East Park Energy

Environmental Statement

Appendix 4-3 EIA Scoping Opinion Response Matrix

September 2025

**Figure 3-3**            ES Illustrative Zoning Plan (Rev P01)

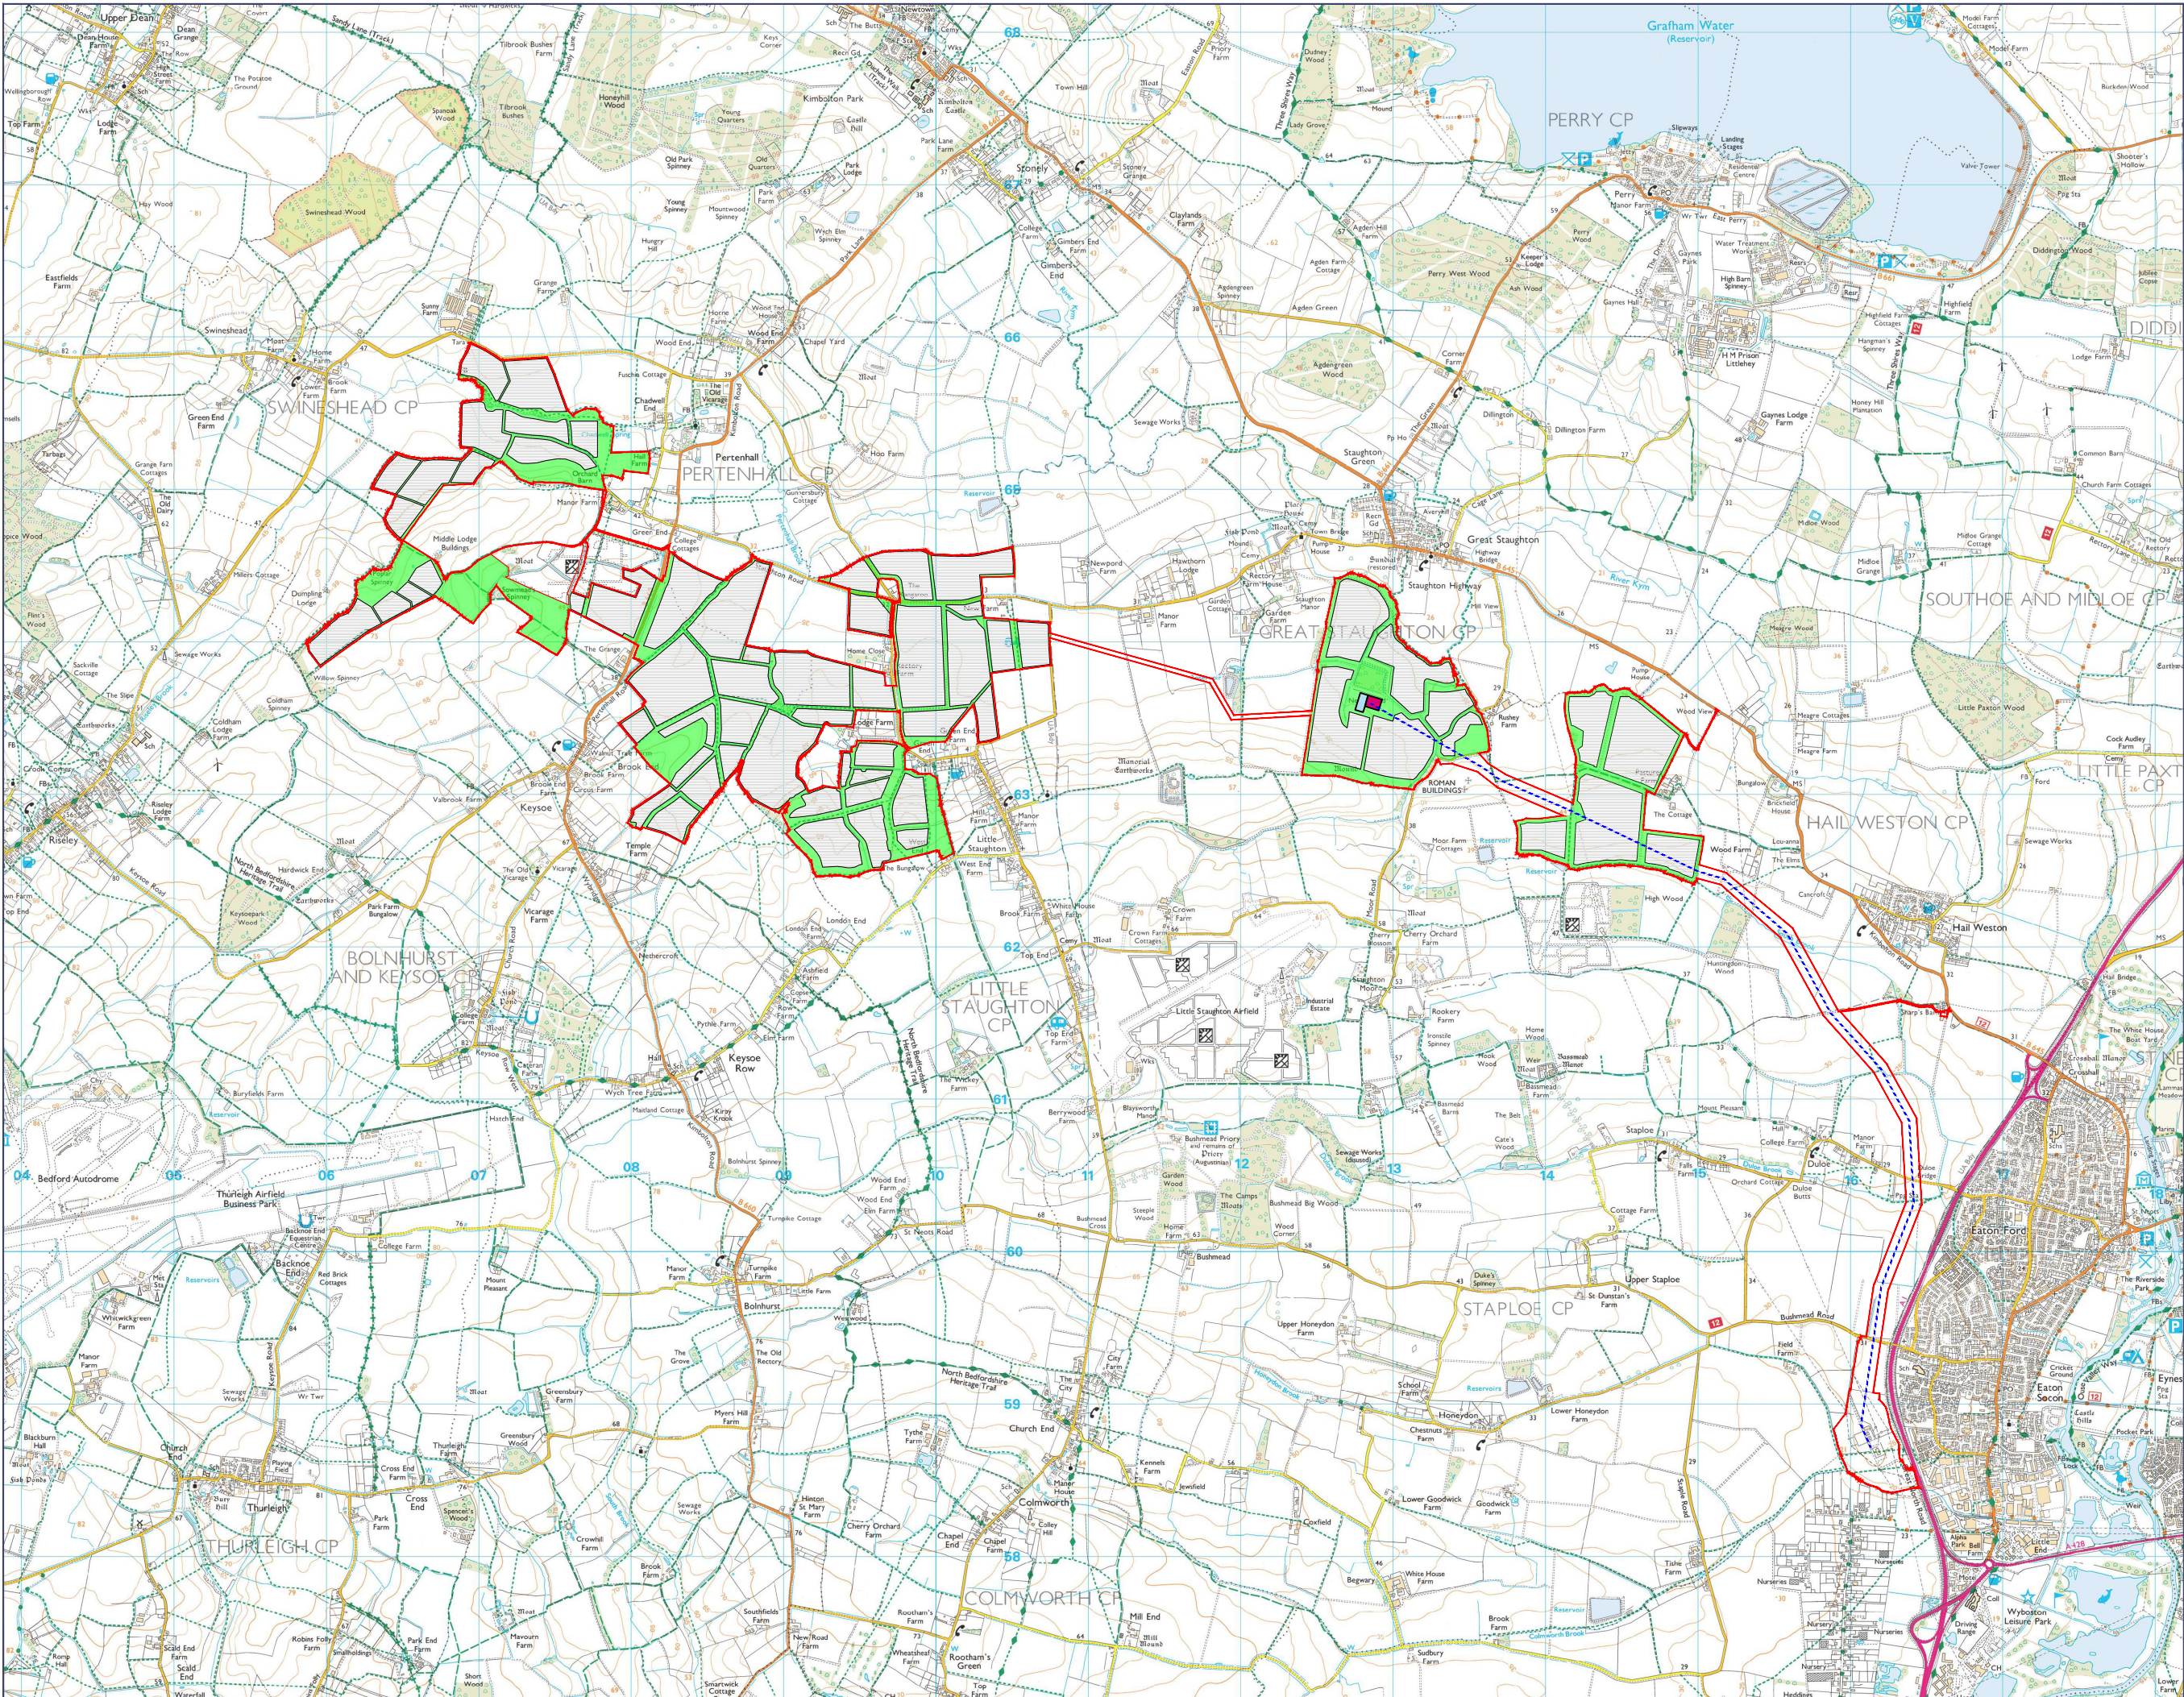
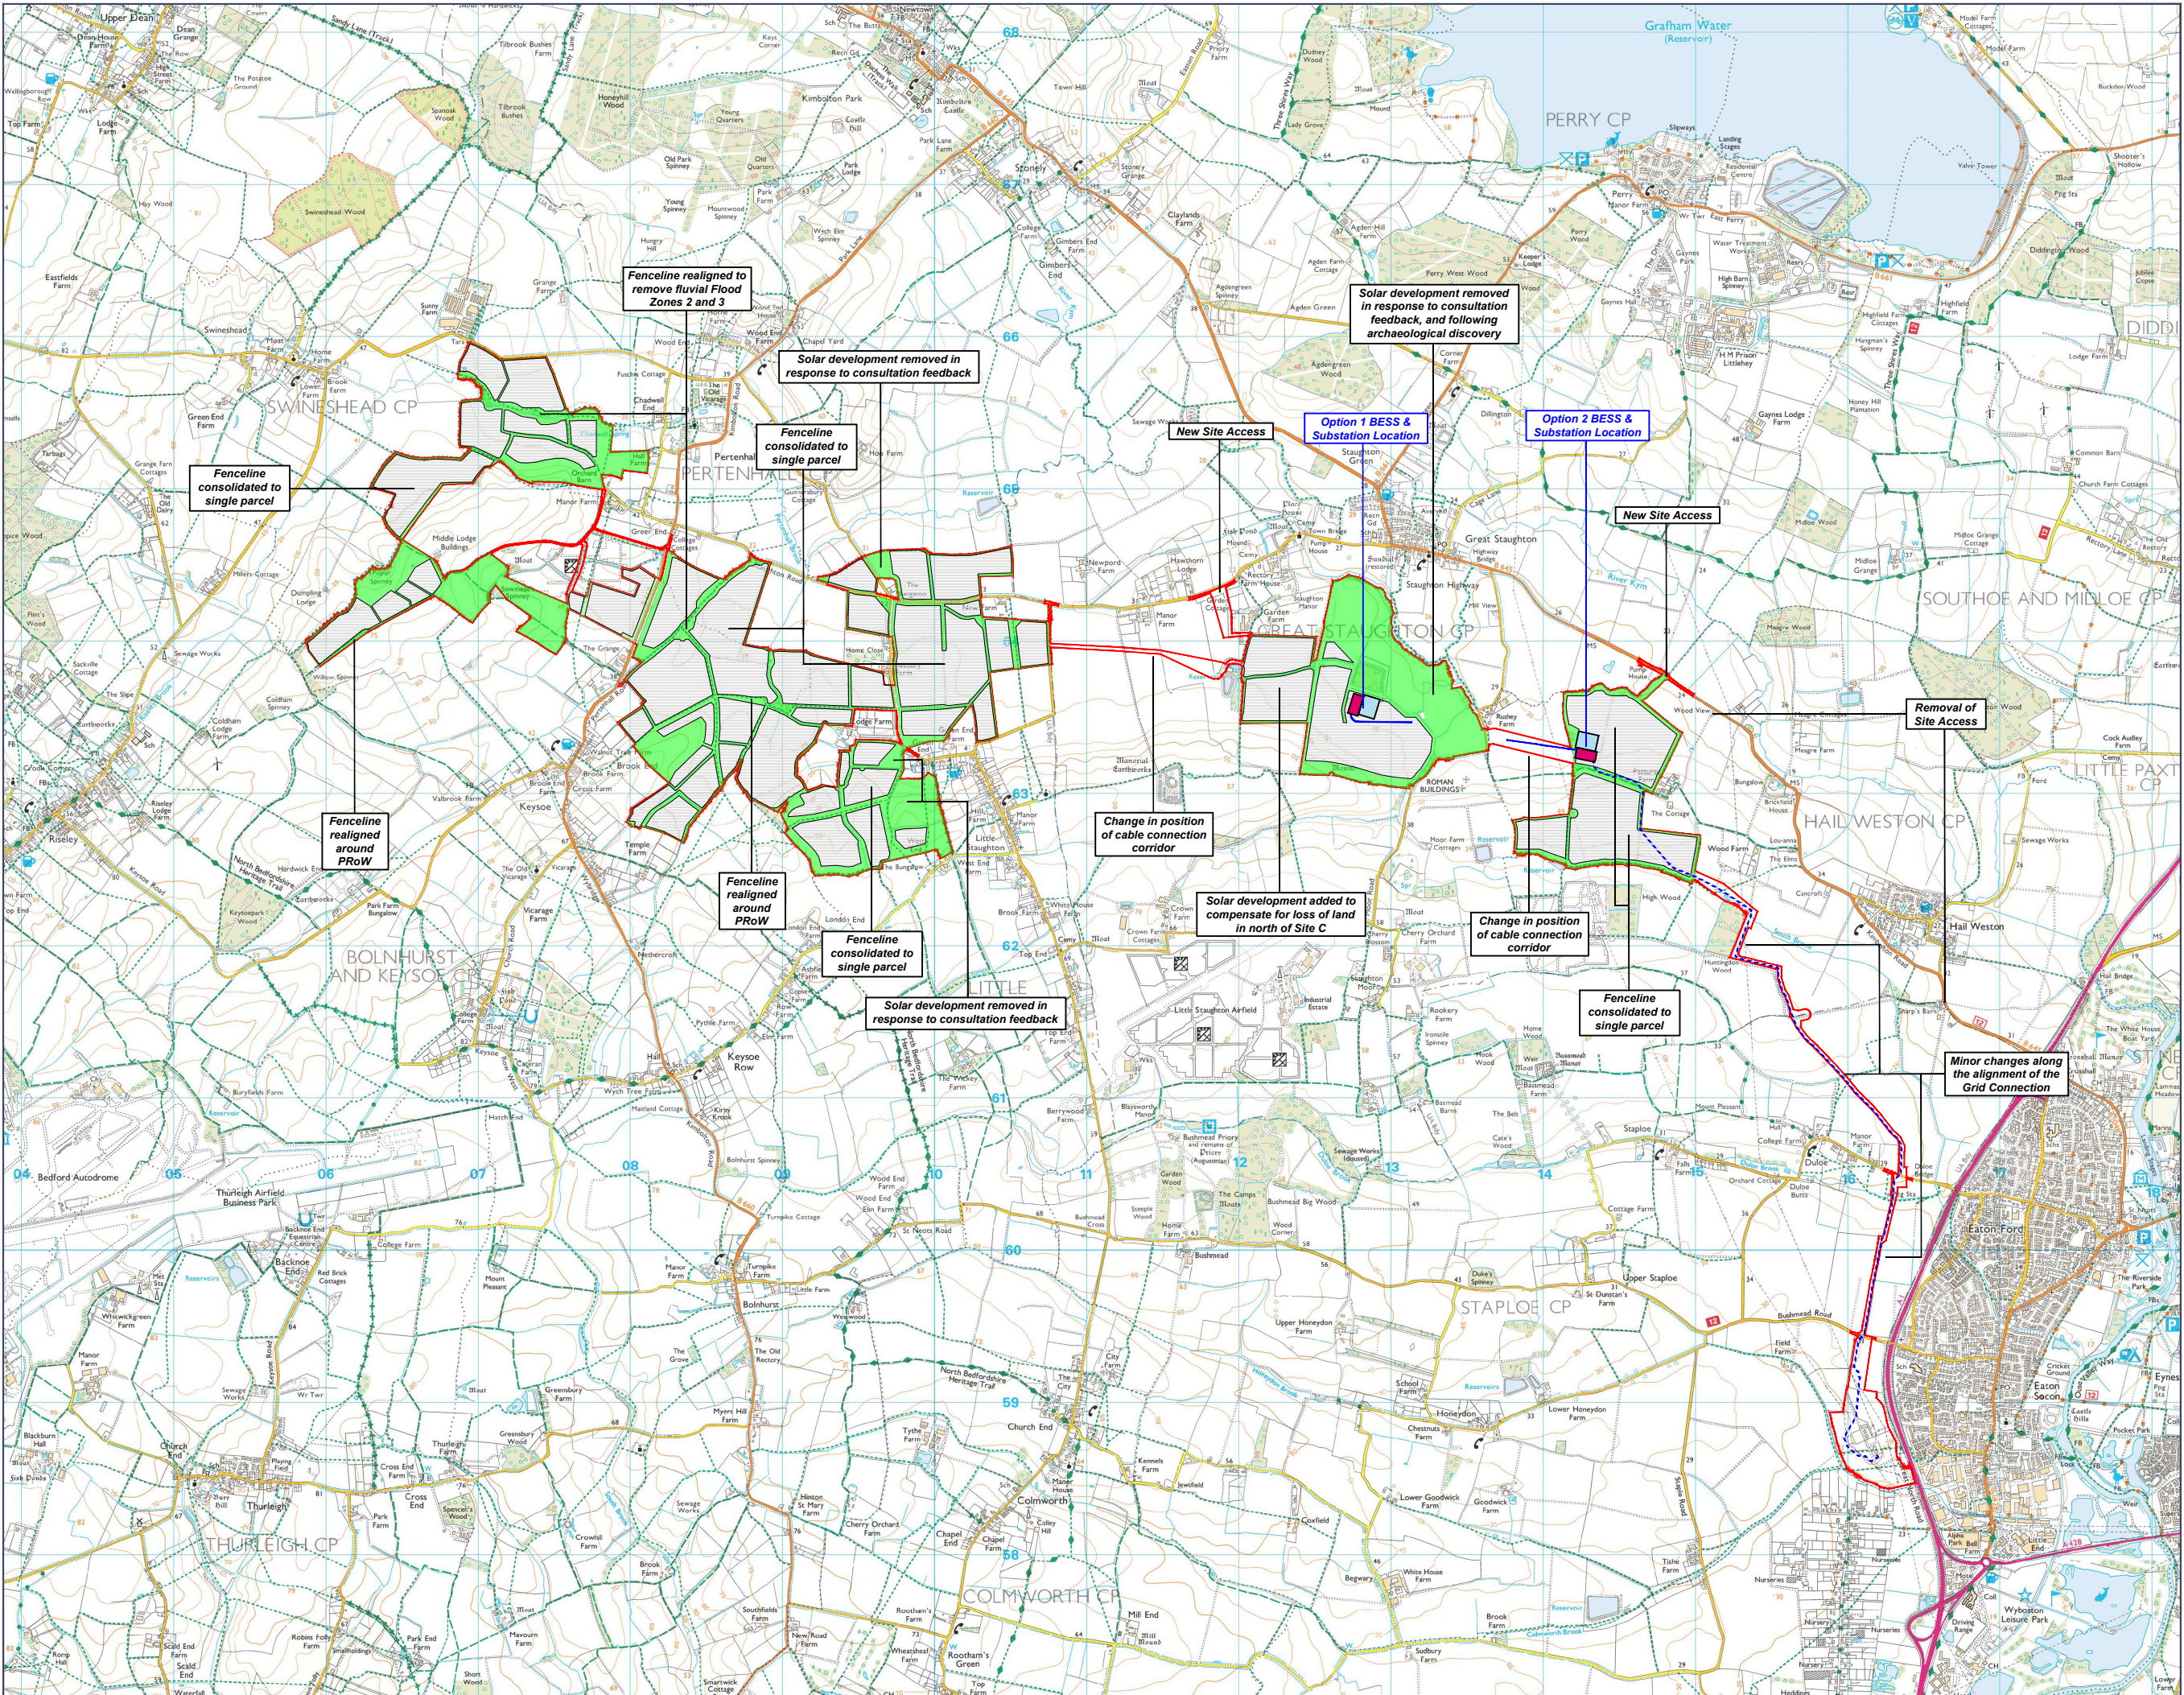
2.2.6	<p>Scoping table</p> <p>The Inspectorate recommends the use of a table in the ES to set out key changes in parameters/ options of the Proposed Development presented in the Scoping Report to those presented in the ES. It is also recommended that a table demonstrating how the matters raised in the Scoping Opinion have been addressed in the ES and/ or associated documents is provided.</p>	<p>This document sets out how the Applicant has responded to the matters raised by the Planning Inspectorate in Sections 2 and 3 of ES Vol 2 Appendix 4-2: EIA Scoping Opinion [EN010141/DR/6.2].</p> <p>ES Vol 1 Chapter 3: Alternatives and Design Evolution [EN010141/DR/6.1] and ES Vol 3 Figures 3-1 to 3-3 [EN010141/DR/6.3] describe the changes made to the Scheme since EIA scoping.</p>
